From: Philip Trueman <ptrueman@hesterarchitects.co.uk>
Sent: 23 July 2021 09:17
To: Richard Phillips
Subject: RE: Morrisons, 41-67 High Street, Yiewsley - 2370/APP/2021/67
Attachments: NBS Yiewsley hard landscape works 08.03.21.pdf; 0811.1.2 YIEWSLEY PLANTING PLAN GROUND FLOOR LEVEL 08.03.21.pdf; 0811.1.4 YIEWSLEYGROUND FLOOR HARD LANDSCAPE 08.03.21.pdf; 0811.1.5 YIEWSLEY PLAY AREA 08.03.21.pdf; 16128 - 530C - Proposed Materials.pdf; 0811.1.1 REV A YIEWSLEY PLANTING PLAN - DECK LEVEL 22.07.21.pdf; 0811.1.3 REV A YIEWSLEY HARD LANDSCAPE DECK LEVEL 22.07.21.pdf; 0811.1.6 REV A YIEWSLEY LANDSCAPE DETAILS 22.07.21.pdf; NBS Yiewsley Soft landscape specification Rev A 22.07.21.pdf; YIEWSLEY LANDSCAPE MANAGEMENT PLAN REV A 22.07.21.pdf; 16128 - 2 - 630 - Privacy Screen Details.pdf; 16128 - 2 - 631 - Podium Privacy Screen Details.pdf; 16128 - 743 - Balcony Privacy Screen - Details.pdf

CONDITION 5: Materials and external surfaces (ref. 2019/2880)

3 Balcony Privacy Screen - Elevation

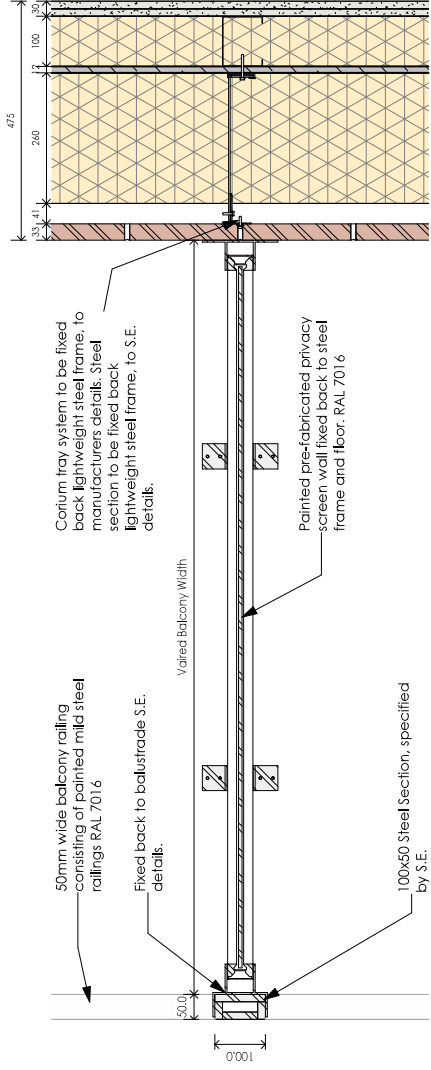
Condition 10 – Privacy Screens

I have attached revised drawings for the Privacy Screens which removes the 45 degree bars in favour of a simple powder coated aluminium screen which should address any concerns about over-looking between properties.

16128 - 743 - Balcony Privacy Screen Details
